KITTITAS COUNTY

MEMORANDUM

SUBJECT: Goebel Short Plat SP-08-30

**GOEBEL SHORT PLAT  
 PART OF SECTION 2, T. 19 N., R. 15 E., W.M.  
 KITTITAS COUNTY, WASHINGTON**

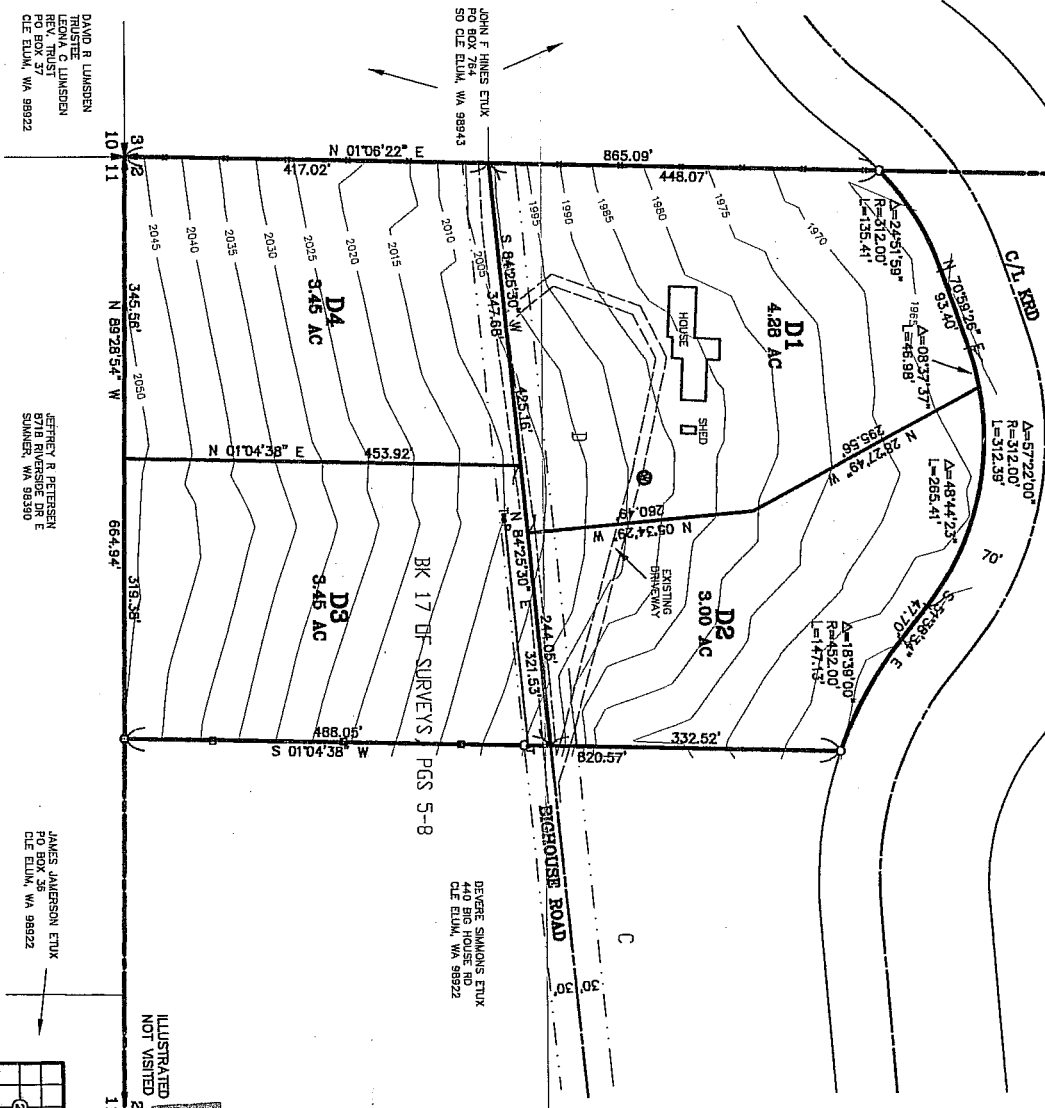
2. Turnaround: A temporary hammerhead or cul-de-sac turnaround shall be constructed at the western lot boundary and shown on the final plat. The temporary cul-de-sac turnaround shall have an outside right-of-way easement diameter of at least 110 feet and when constructed, the driving surface shall be at least 96 feet in diameter. The temporary easement may be abandoned when the road is extended. Hammerheads and cul-de-sacs must also conform to the requirements specified by the 2006 International Fire Code. Contact the Fire Marshal regarding any additional cul-de-sac requirements.

3. Private Road Improvements: Access from Upper Peoh Point Road to the turnaround shall be constructed as a Low-Density Private Road. See Kittitas County Road Standards, 9/6/05 edition.

- a. Access easements shall be a minimum of 60' wide. The roadway shall have a minimum width of 20', with 1' shoulders, for a total width of 22'.
 - b. Minimum centerline radius will be 60'.

- c. The surface requirement is for a minimum gravel surface depth of 6".

- d. Maximum grade is 12%.
 - e. Stopping site distance, reference AASHTO.
 - f. Entering site distance, reference AASHTO.
 - g. Maintenance of driveway approaches shall be the responsibility of the owner whose property they serve. The County will not maintain accesses.

- j. All easements shall provide for AASHTO radius at the intersection of county road.
 - k. A paved apron shall be constructed at the intersection of the proposed private intersection and the county road right of way.
